DISH WIRELESS, LLC. SITE ID:

DNDEN00369A

DISH WIRELESS PROJECT INFORMATION
**US-CO-5035
FOUNTAIN
82 WIDEFIELD BLVD.
COLORADO SPRINGS, CO.
80911**

SHEET TITLE
TITLE SHEET

SHEET TITLE
TITLE SHEET

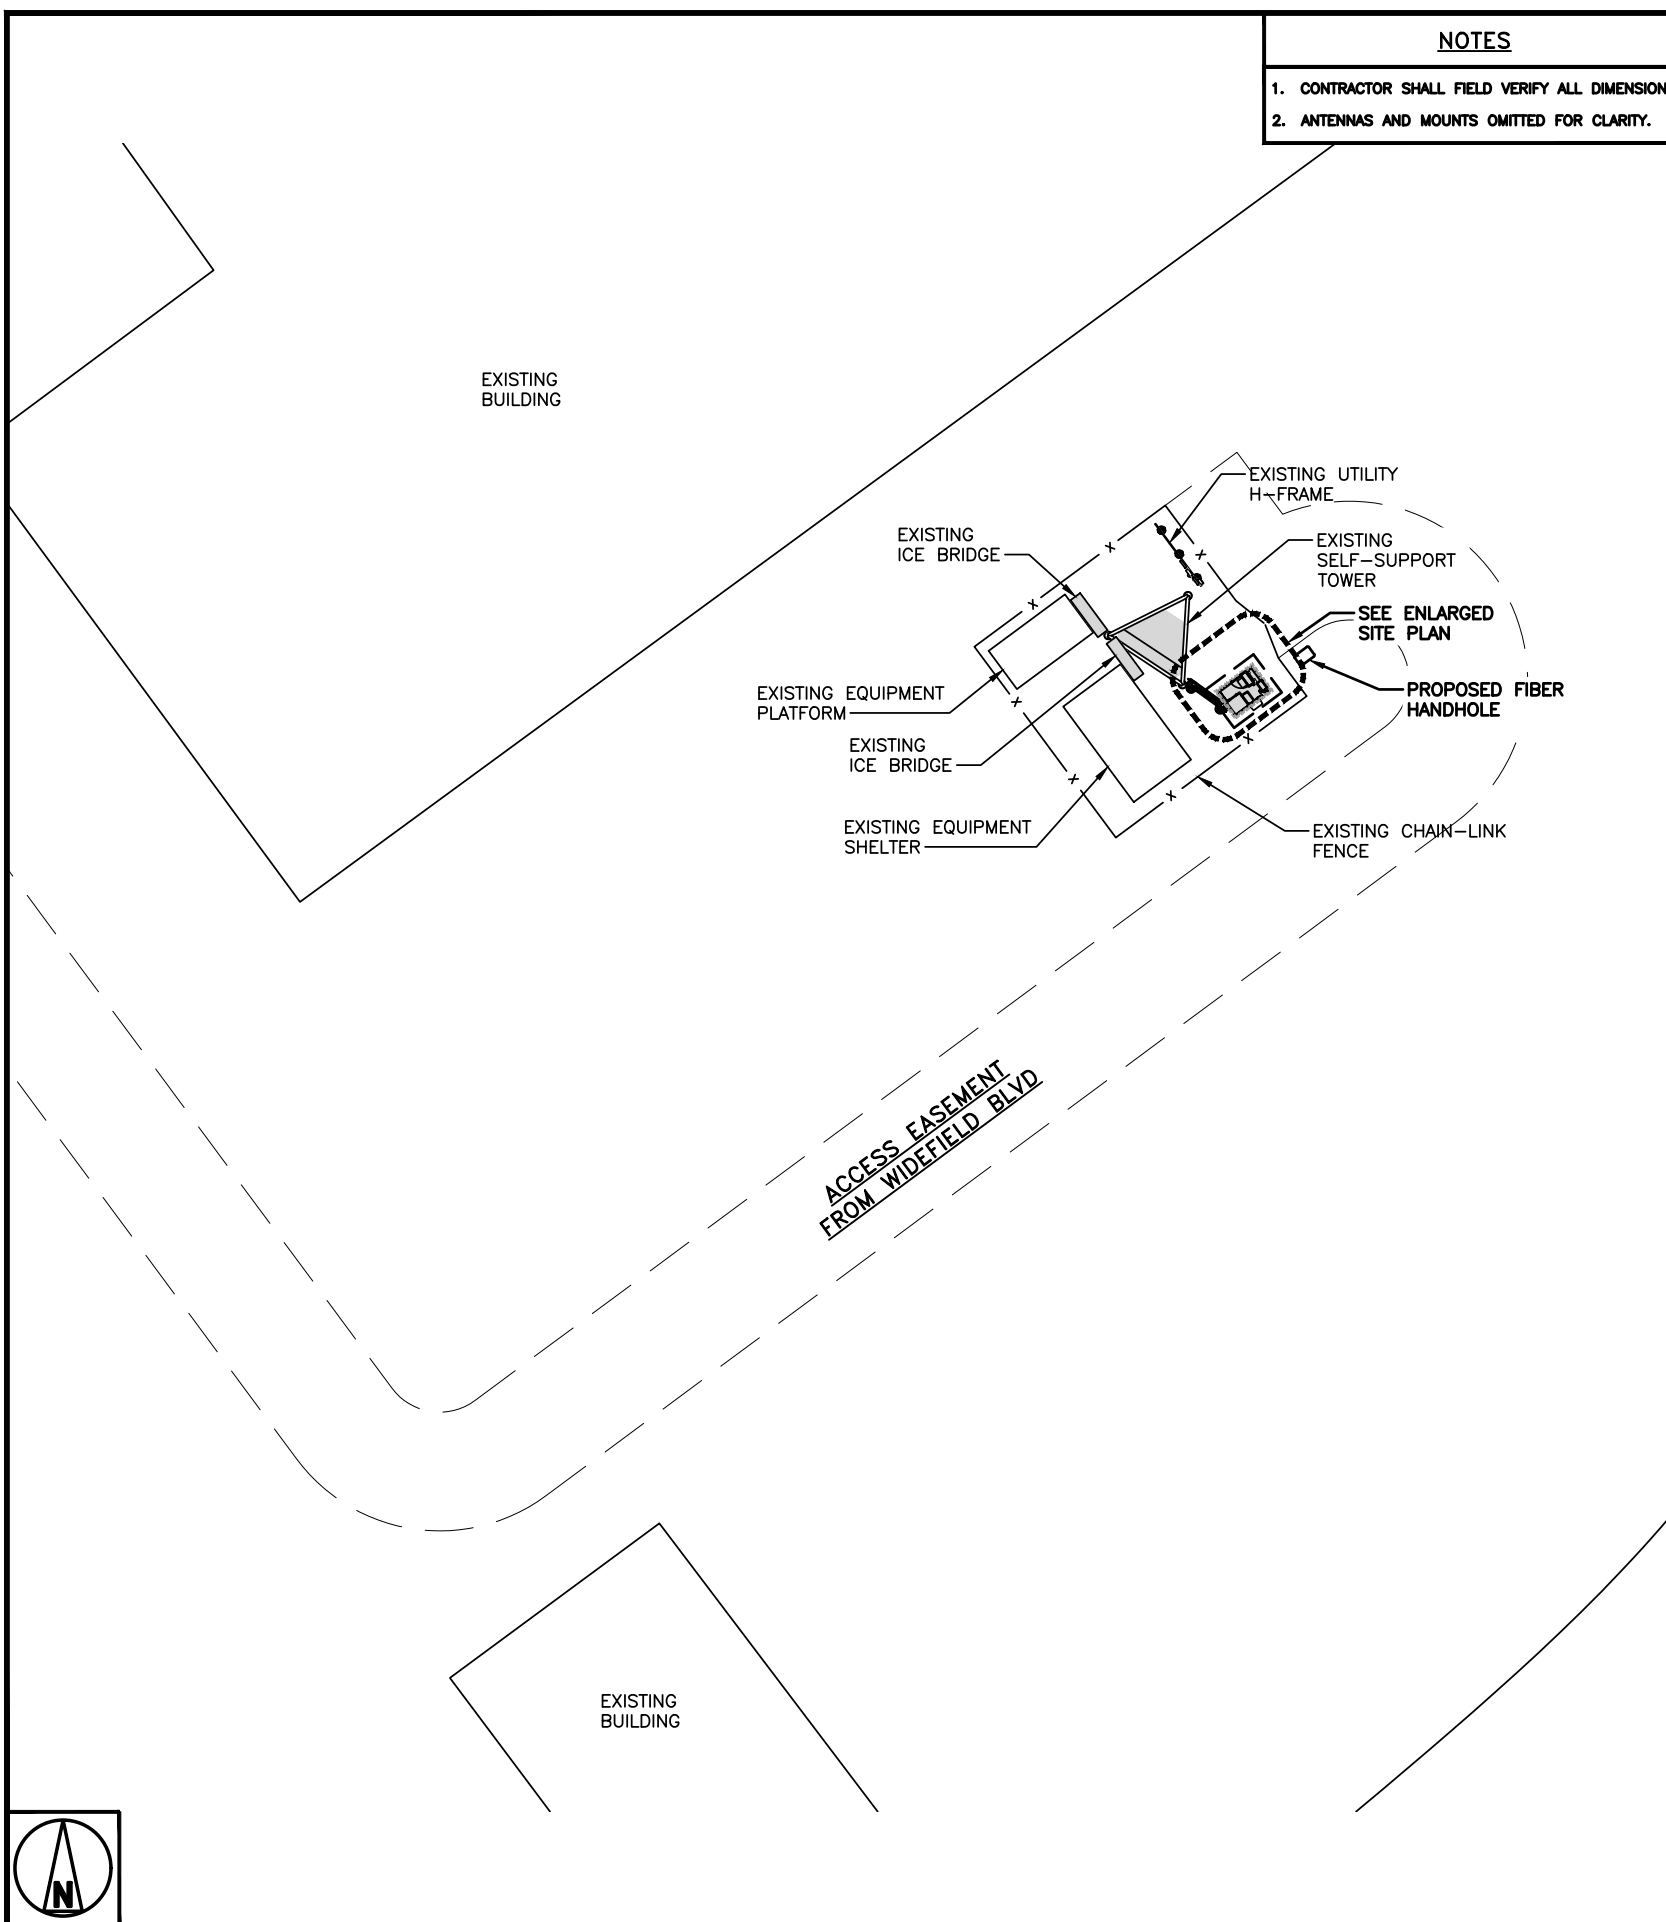
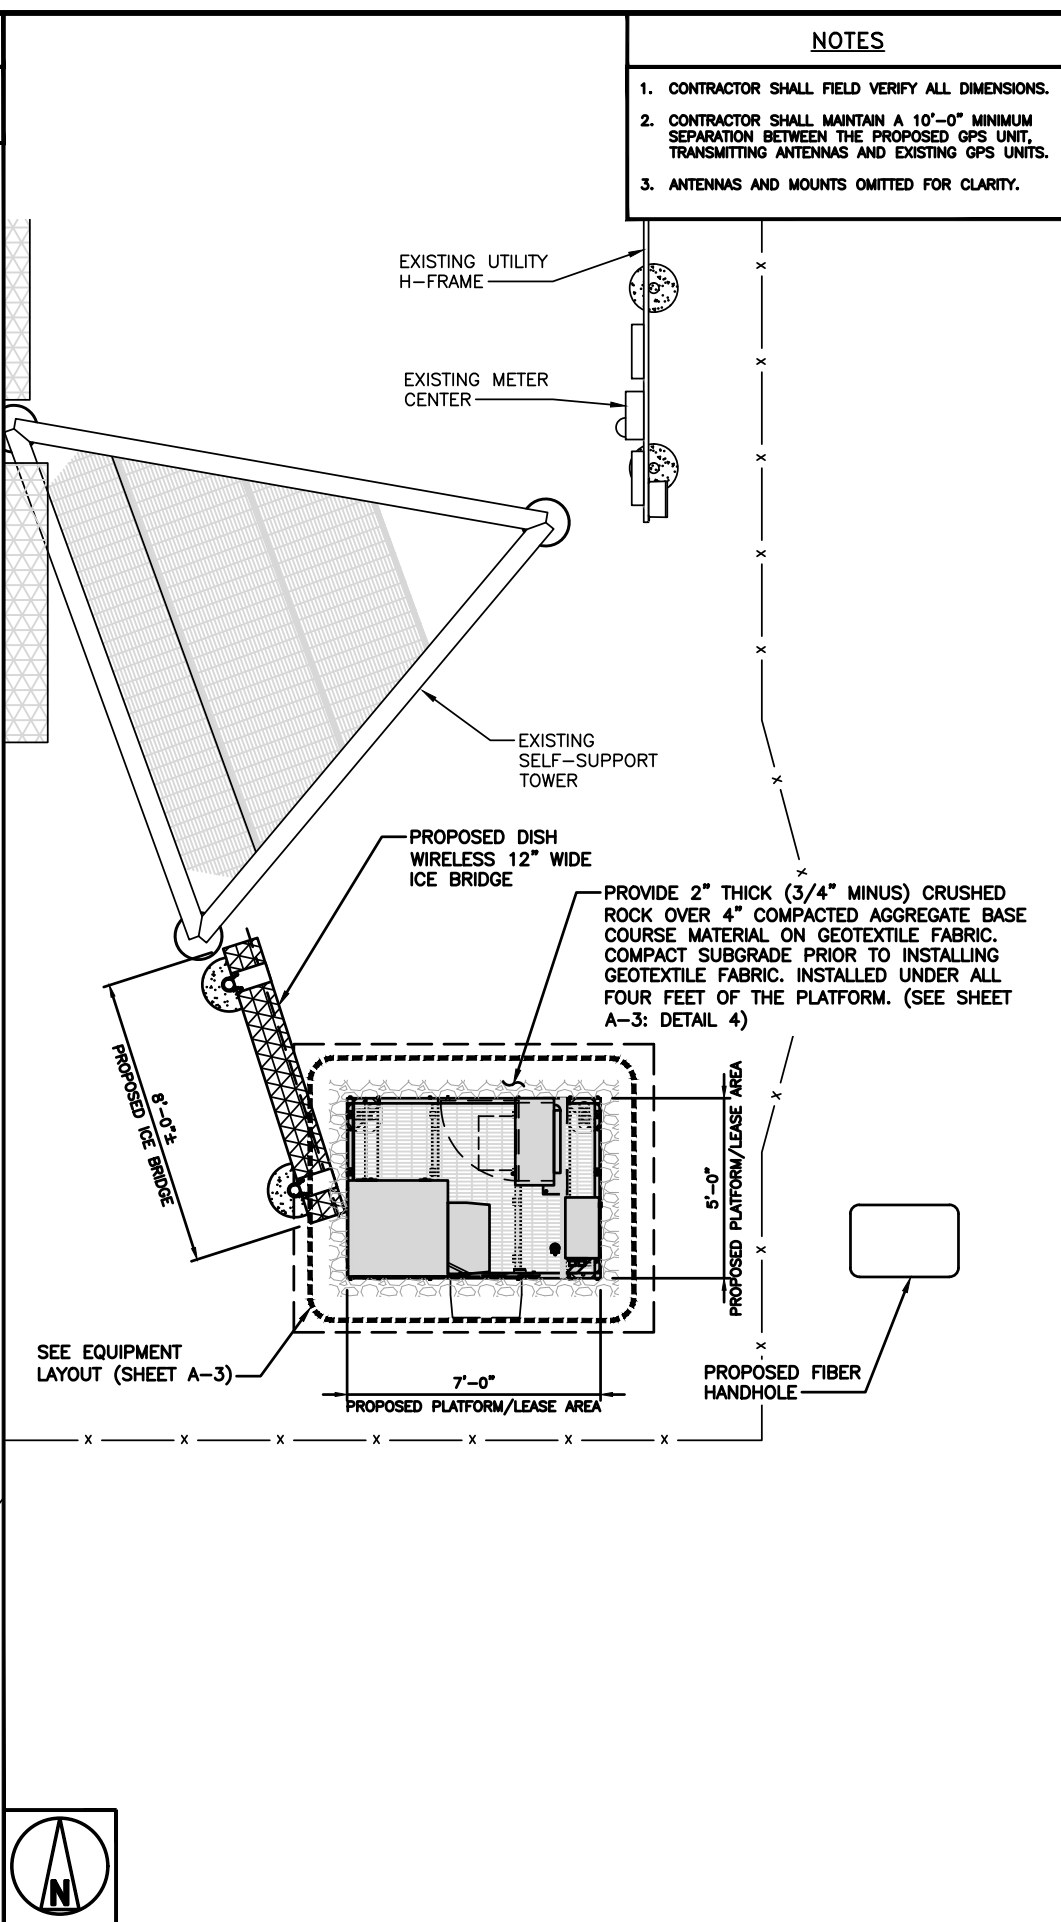
- Owner name, contact telephone number, and email for responsible party
- Plan preparer name, telephone number, and email
- Property tax schedule number
- Legal description
- Lot/parcel size
- Lot area coverage calculation
- Existing zoning
- Total gross building square footage
- Vicinity map showing the subdivision in relation to section lines and existing or proposed arterial or collector roadways.

Please add "PCD File No. TWR-21-007".
